Application BE/151/11 – amended indication of layout and gates

New layout and gates

SHRIPNEY GARDEN CARAVAN PARK, SHRIPNEY LANE, SHRIPNEY
Proposals 01 B
Nov 2011

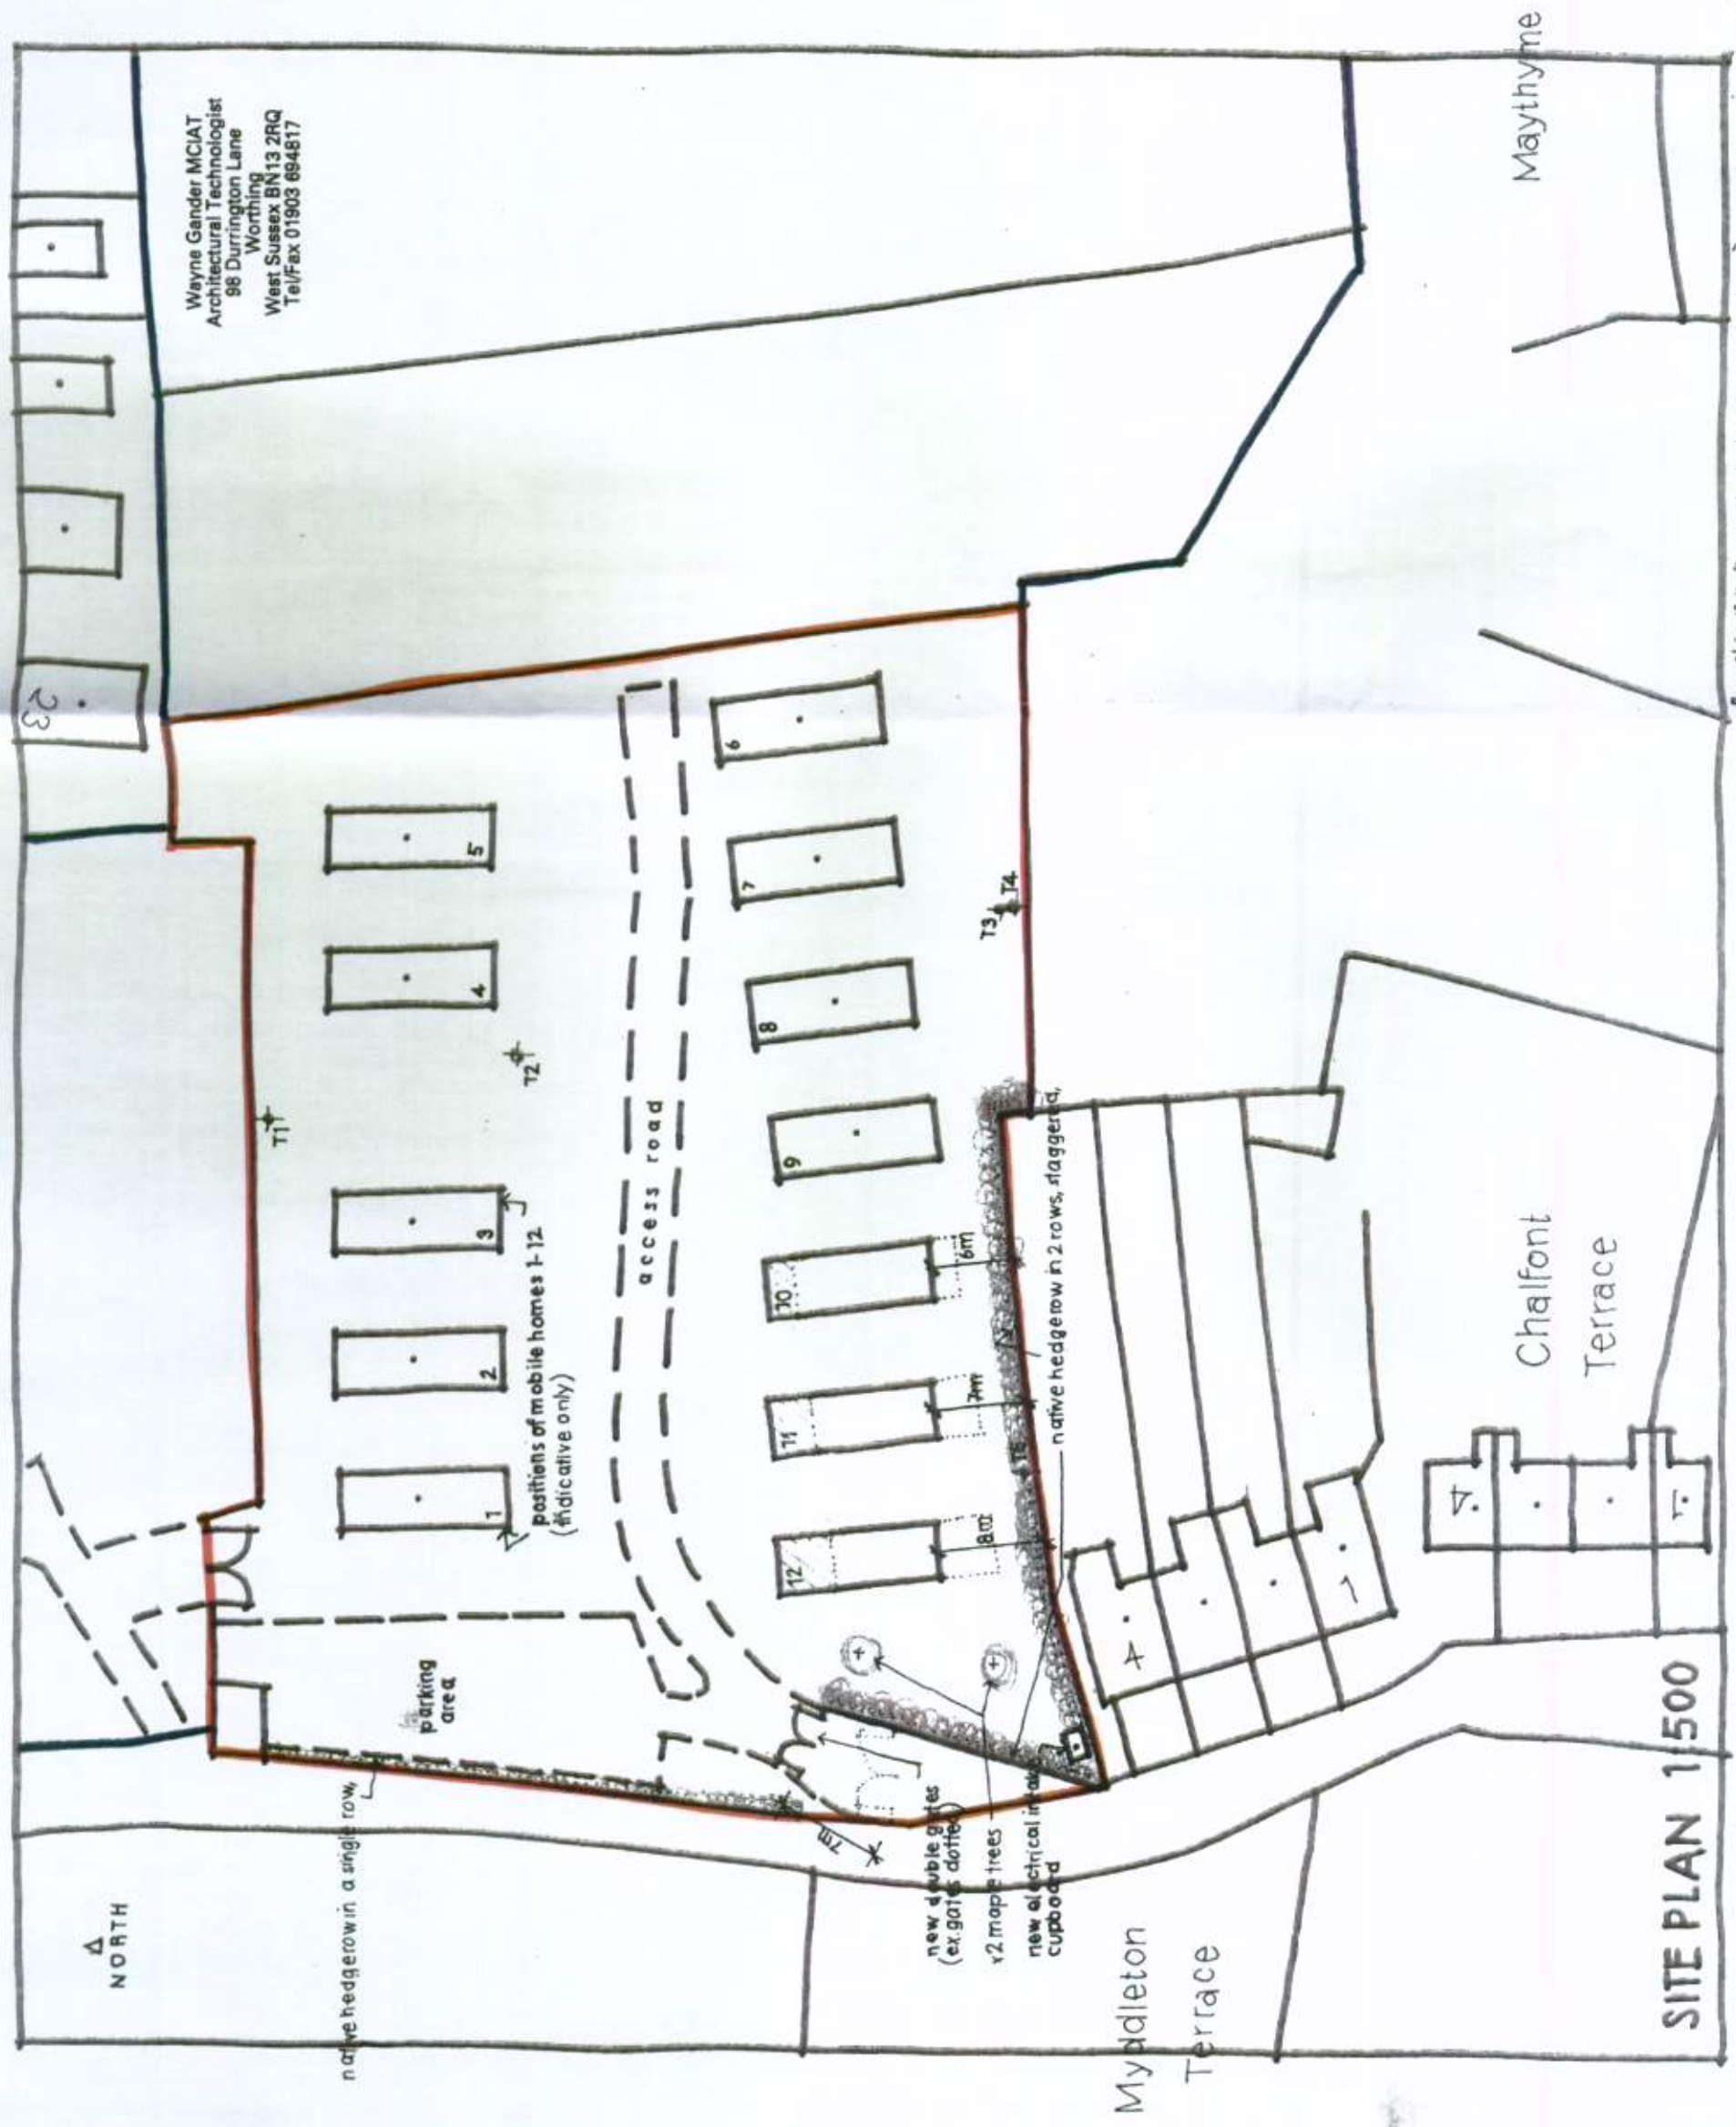
The new layout is a small improvement on previous applications however there are still significant developments that I object to and I request that Arun DC do so as well.

1. The wall that provided screening of the site from the access road has been demolished by the applicant. The wall should be replaced, in brick. However at least the mixed native hedging is preferable to the conifers that are totally out of keeping with the landscape. However the hedging along the road should be double width.
